Date: 05-Apr-2024
Our Ref: 2024/90901

**Non material amendment to previous permission 2023/91393 for Demolition of existing sales building and erection of new sales building, installation of 3 new jet wash bays, electrical vehicle charging bays with associated infrastructure, de-link of existing forecourt canopy, and associated forecourt works
Salendine Filling Station, New Hey Road, Salendine Nook, Huddersfield, HD3 3UZ
Application Number: 2024/90901**

DRAWING TITLE
 PROPOSED SITE ELEVATIONS
 NON MATERIAL VARIATION APPLICATION

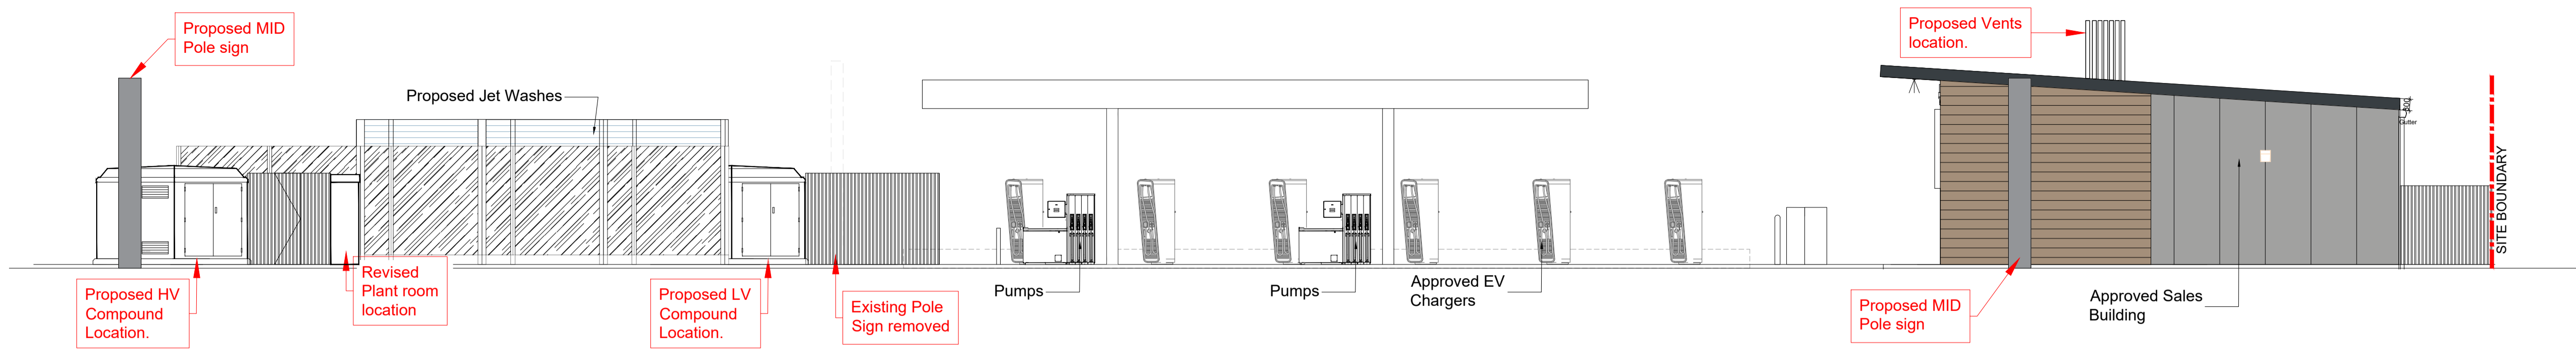
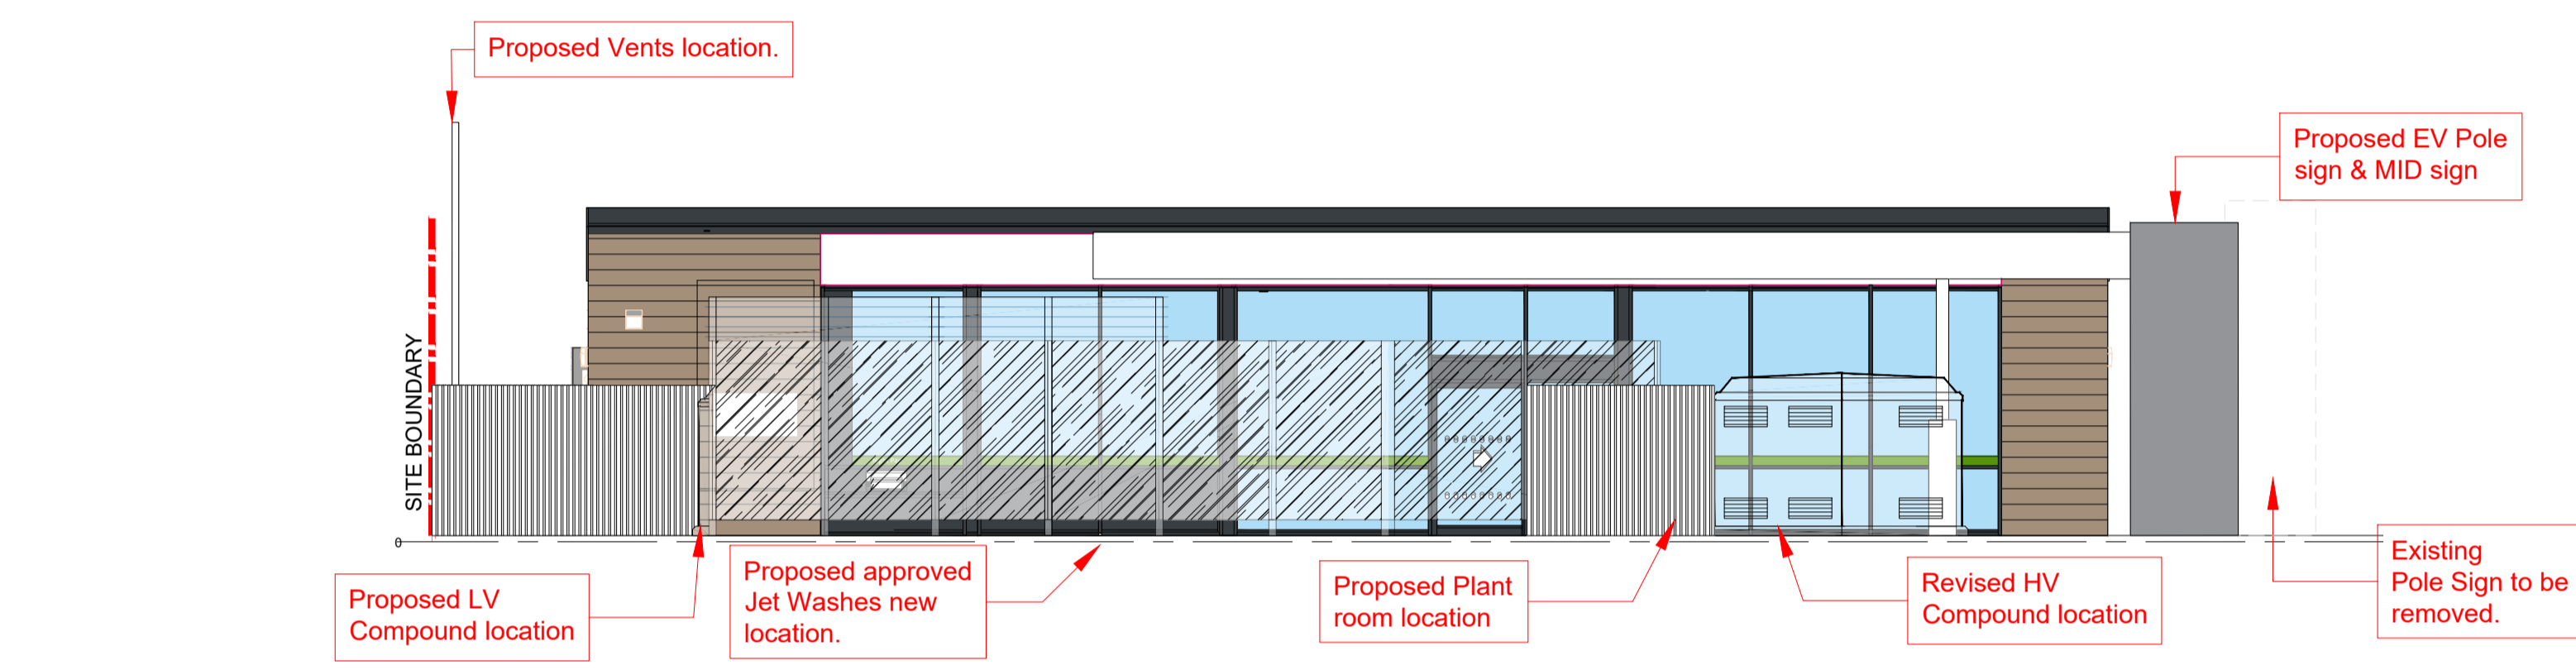
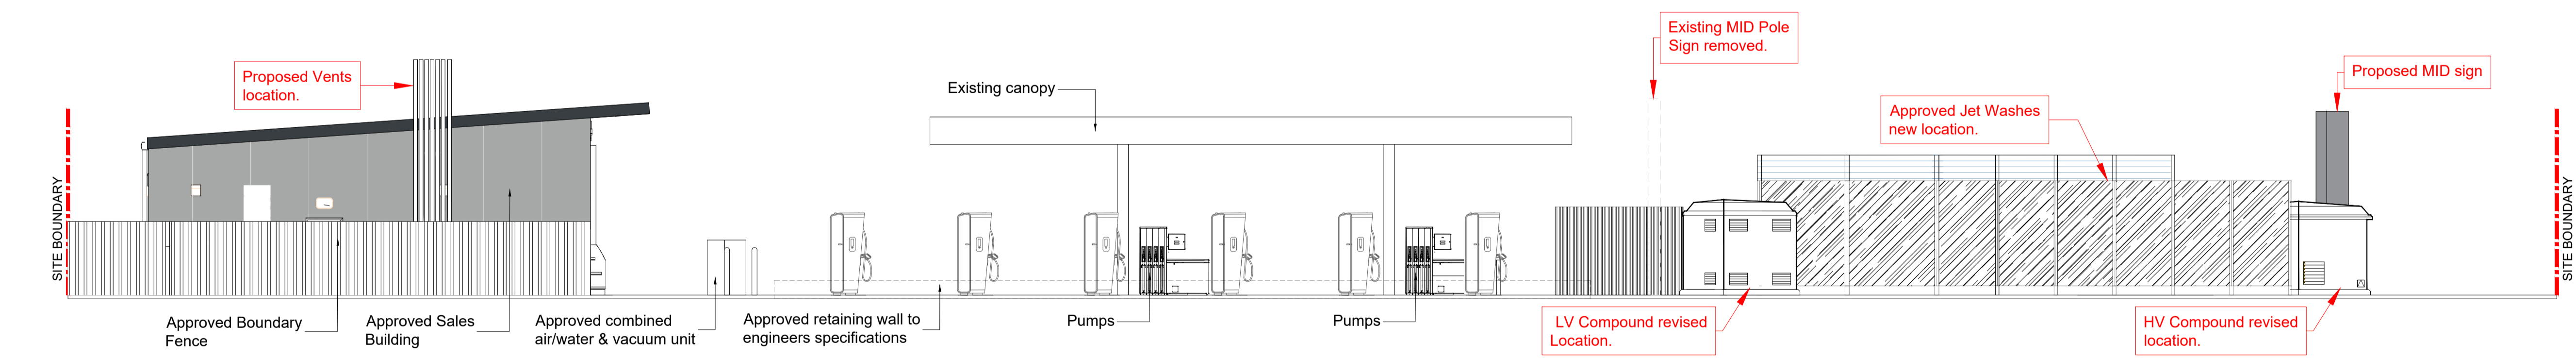
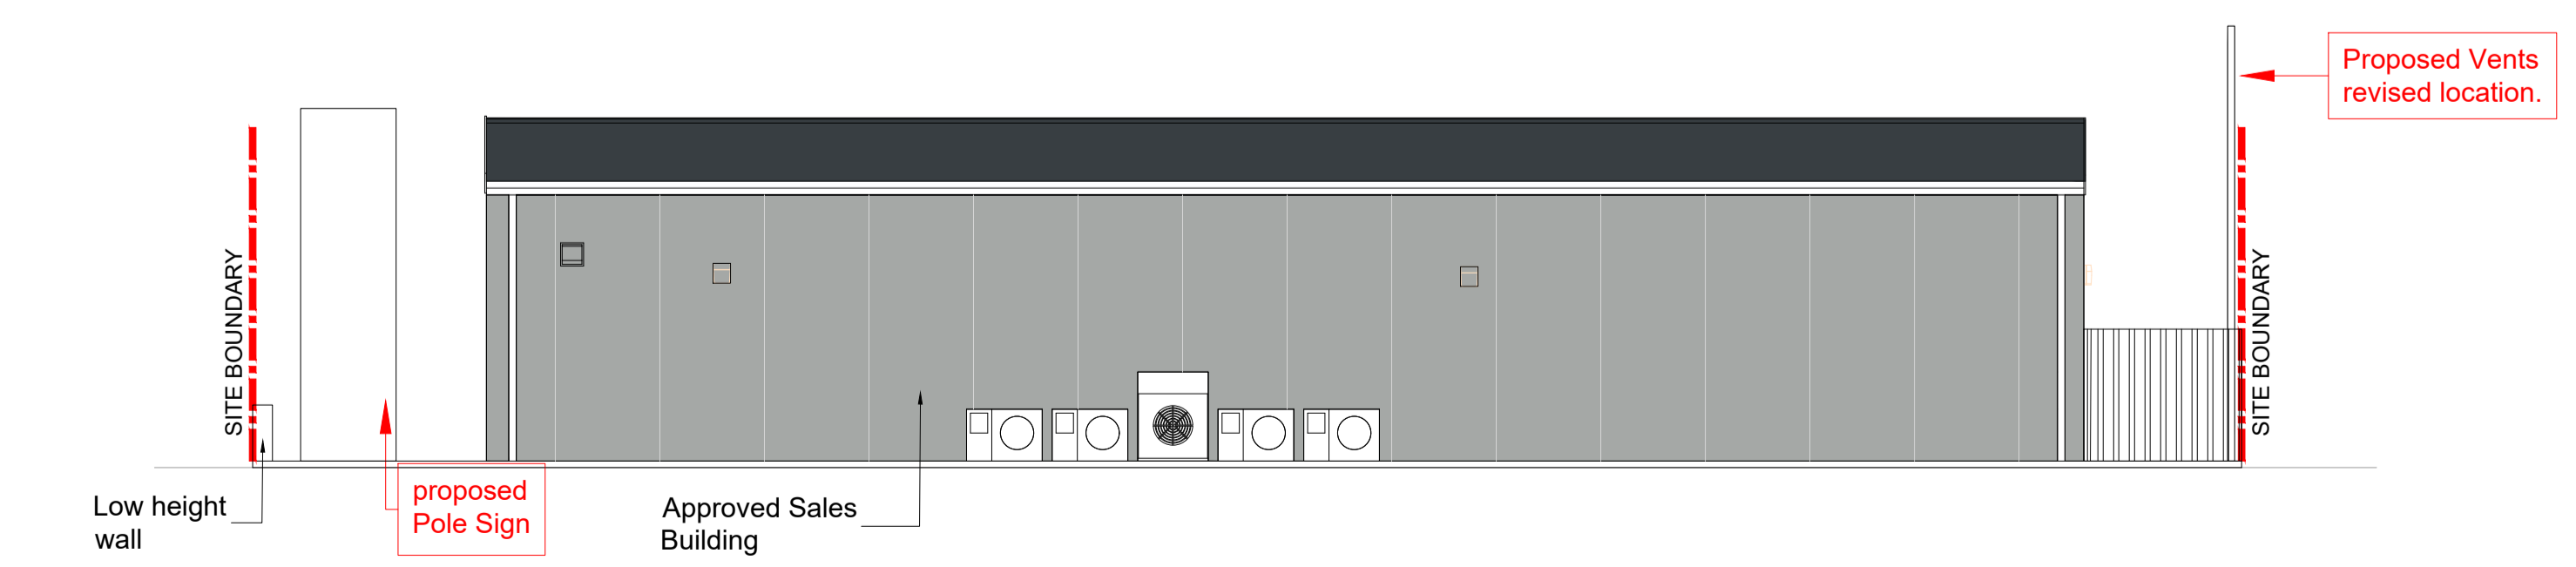
I am only able to consider non-material amendments to plans approved under a previous planning permission which are minor and do not materially change the appearance or character of the previously publicised scheme. The proposed alterations to the approved plans extend beyond this and hence I am unable to accept them.

The proposed alterations and relocation of jet wash bays, substation, meter cabinet, LV unit, plant room, vent stack and pole (and MID signs which would require a separate application for advertisement consent) within the application site are material amendments to the originally approved scheme.

A new application will therefore be required which will be subject to a further round of publicity and consultation.
